**Consultation Response from KC,  
Highways Development Management**

**2024/92168 Land south of, Leak Hall Barn, off Leak Hall Lane, Denby Dale, Huddersfield, HD8 8QU**

**Outline application for erection of residential development of 13 dwellings**

**Responding Ref: K17-12-24**

DRAWING TITLE
VEHICLE TRACKING AND VISIBILITY

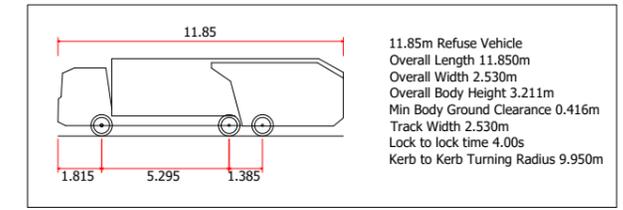
Visibility splays have been demonstrated of 2.4m x 25 to the right out of the development and to left which is within the RLB of the site – not specified. Given the achievable visibility indicated it is important that driven speeds are established on the approach from Leak Hall Lane, this should be undertaken via a 7 day automatic speed survey to give robust information on vehicle speeds.

With regards to visibility to the left an indicative dimension of the achievable visibility should be provided, it is acknowledged that this is a private drive with minimal traffic so the requirements in terms of distance can be relaxed somewhat. It should be noted however that this needs to be maintained in perpetuity, via adoption or maintenance agreement so clarification is sought on this matter.

Speed surveys and visibility into the site access commensurate with the survey results which is considered acceptable.

Before development commences, any obstruction shall be set back to the rear of the proposed visibility splays as shown on approved plan number (24301)- REV D and shall be cleared of all obstructions to visibility and tarmac surfaced to current standards in accordance with details that have previously been approved in writing by the Local Planning Authority.
